I am writing on behalf of the British Horse Society (BHS) a membership charity with over **125,000** members representing the UK's **3 million** regular riders and carriage drivers, in response to the Light Valley Solar Ltd Project. The BHS is the largest and most influential equestrian charity in the country, working to improve the lives of horses and their owners through its four core foundations of education, welfare, safety and access.

**The BHS objects to the DCO.** The BHS objects to this application on the grounds that the application does not meet the tests of NPPF Paragraph 105. The BHS objects on the grounds that equestrians are being marginalised in the scheme with walkers and cyclists being favoured. Throughout this scheme equestrians are excluded, the arguments for inclusivity of walkers and cyclists can be extended to equestrians using the mechanism of the Equality Duty. This is a form of discrimination, and the Equality Act 2010 created a Public Sector Equality Duty for authorities to provide equal opportunities for all, which means that an authority needs a cogent reason for excluding equestrians.

Project Name  
**Light Valley Solar**

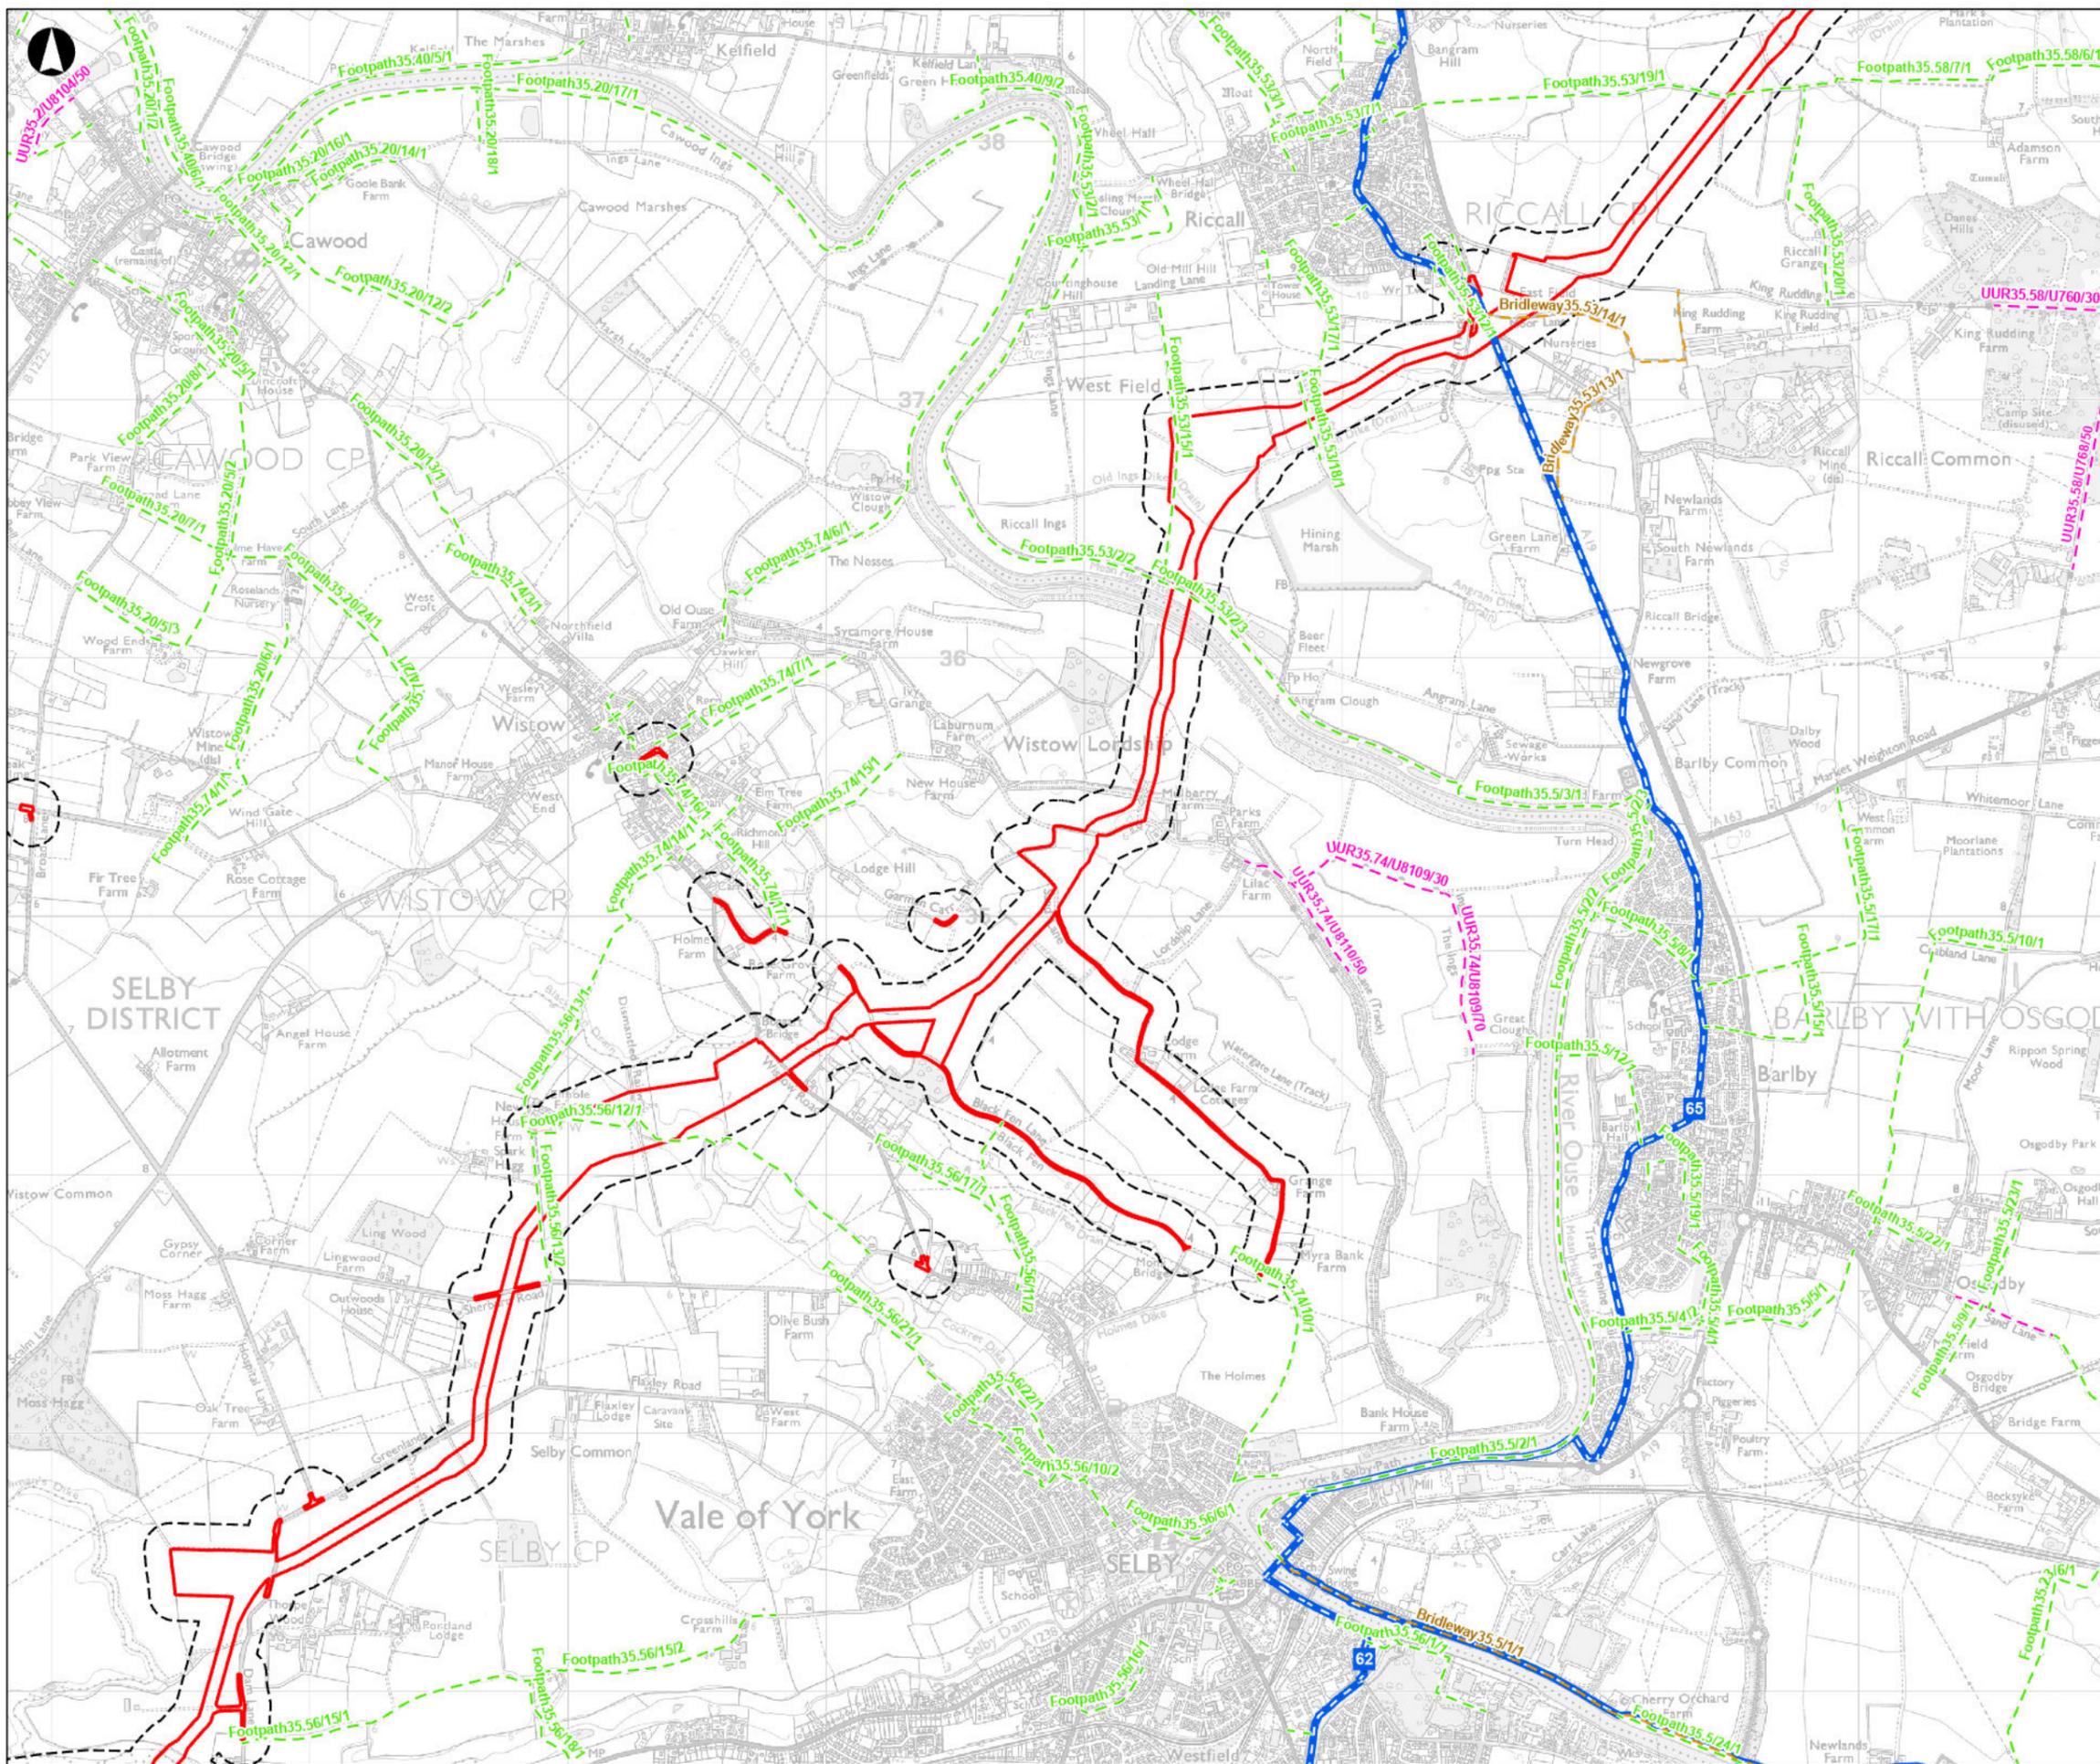
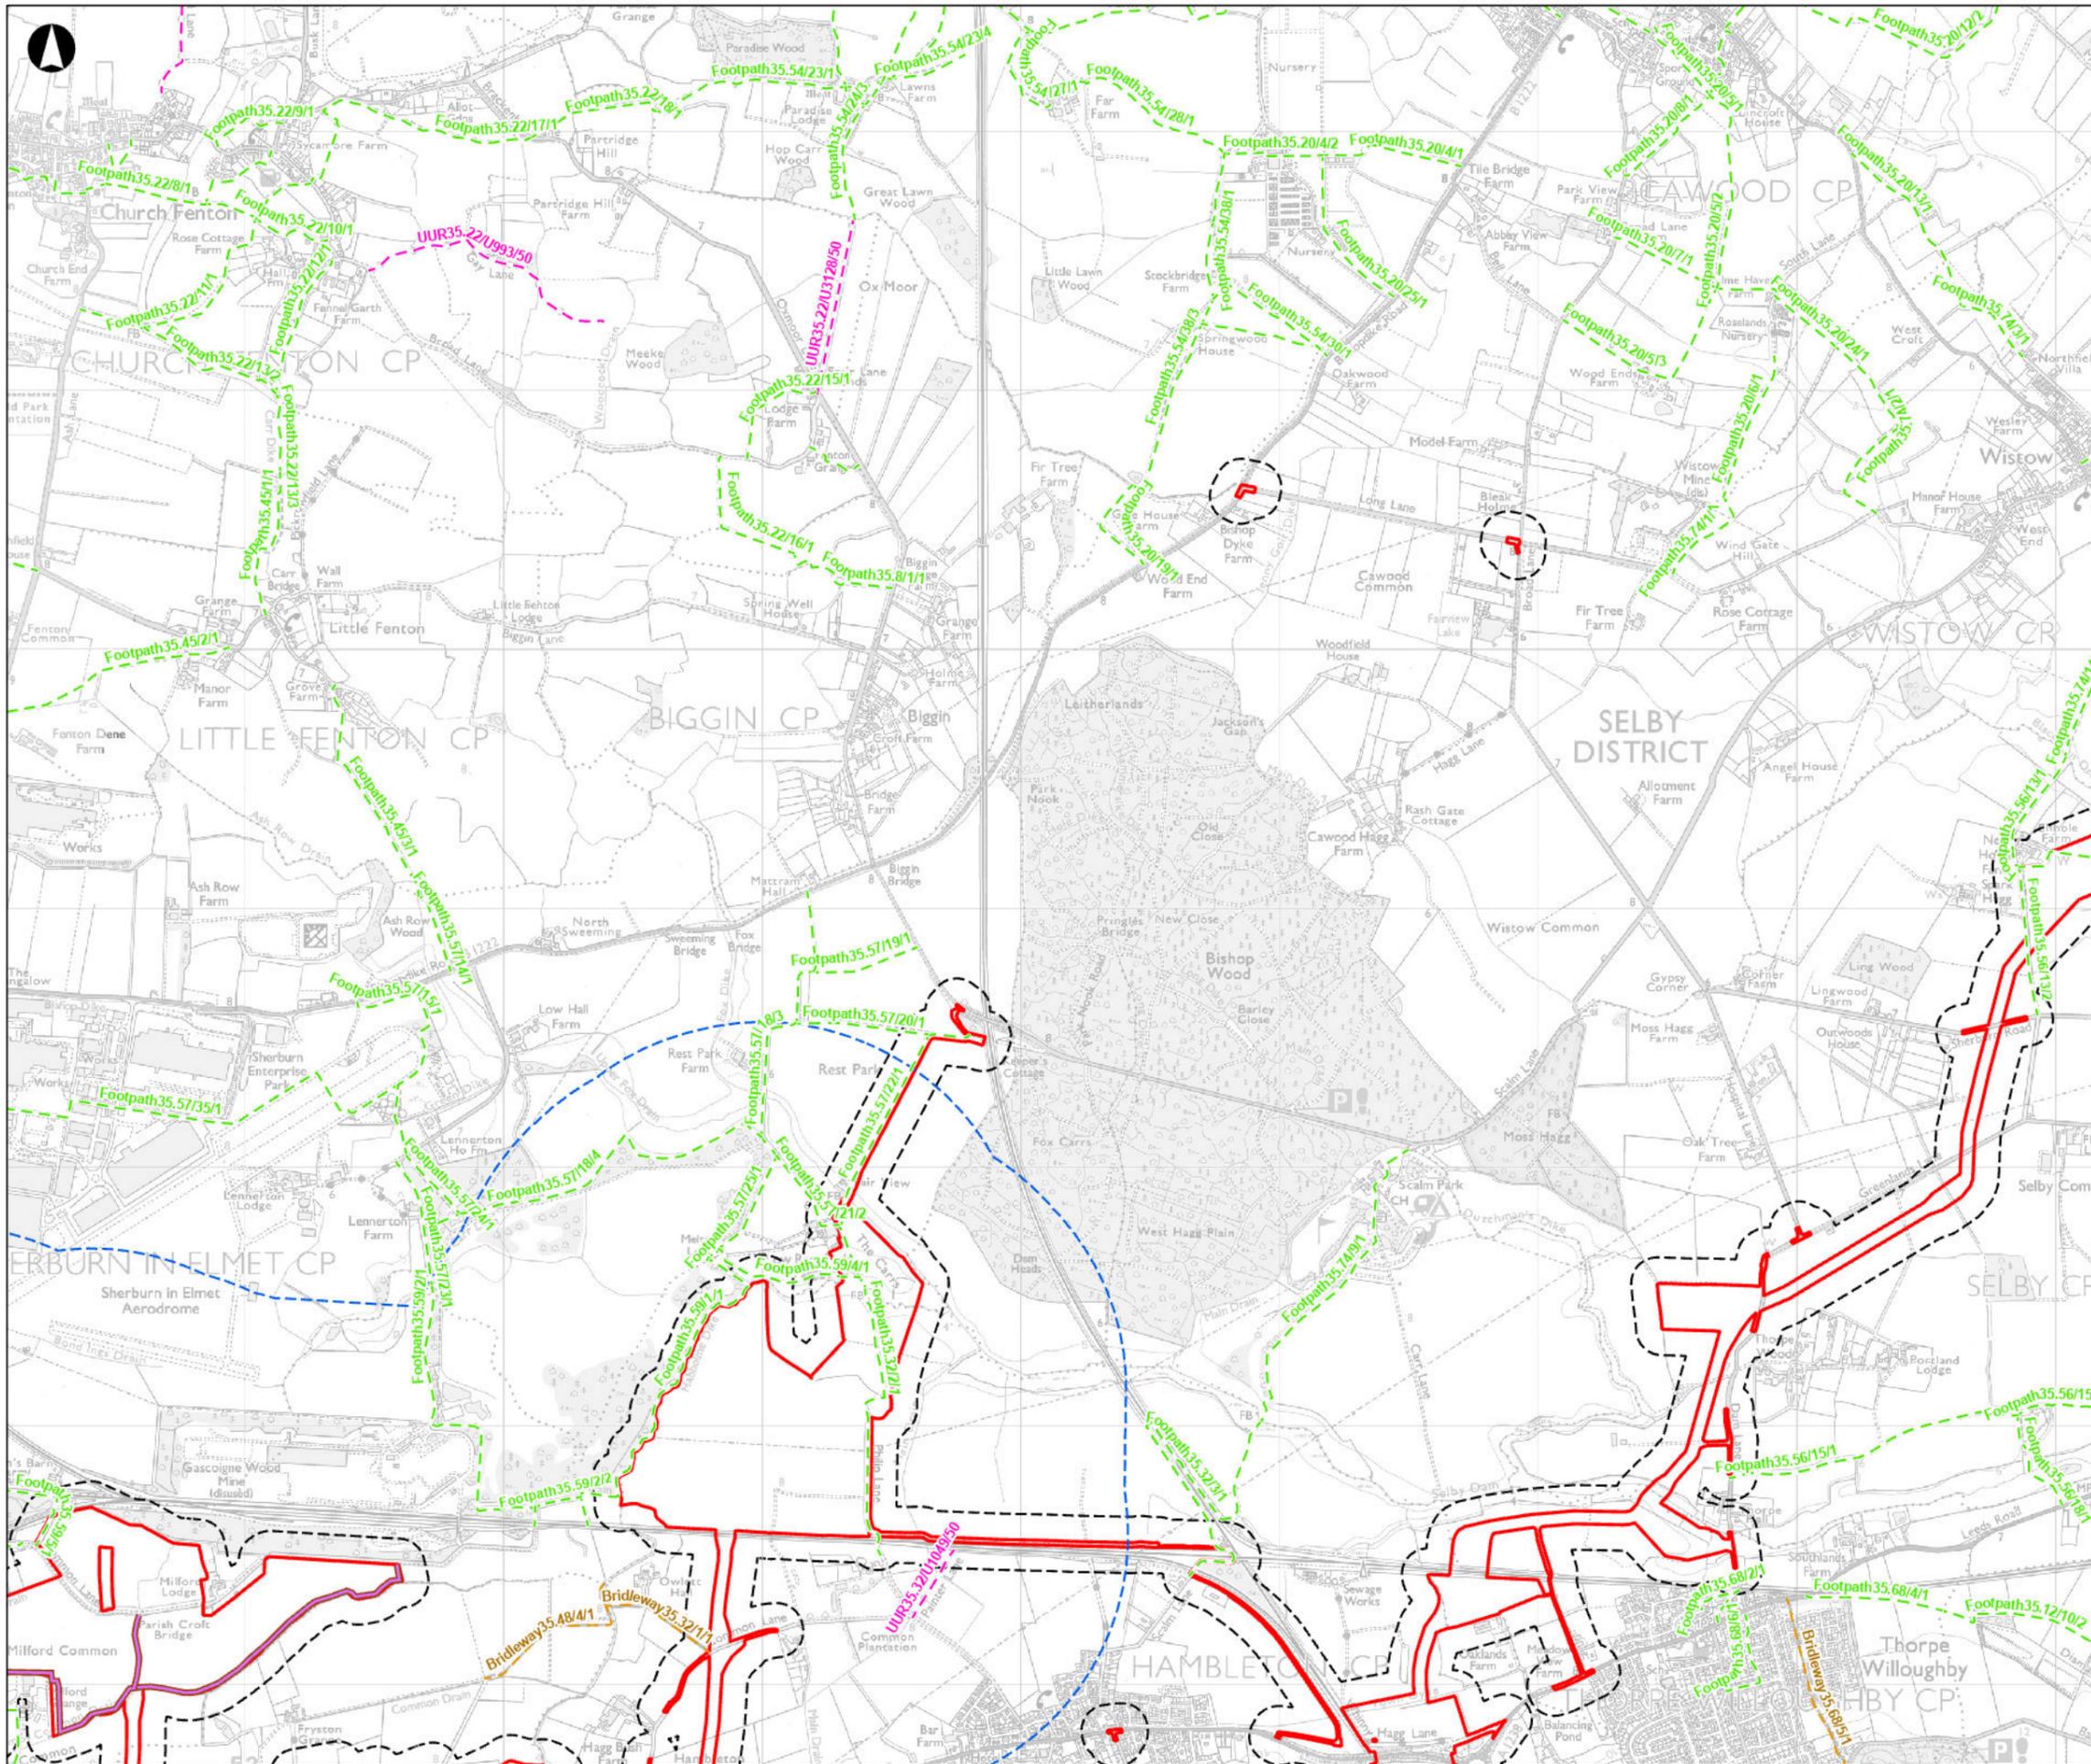
Permissive paths should be multi-user and made available for all NMU users not just walkers and cyclists it should be noted that cyclists can legally use bridleways it therefore makes more sense that these permissive paths be multi-user.

The distances of Permissive paths within the scheme are shown as a mere 8km which does not seem appropriate for a scheme of this size. We would like to see the distances available to each user group broken down by length, IE permissive path length available to Pedestrians separated from both cyclists and horse riders.
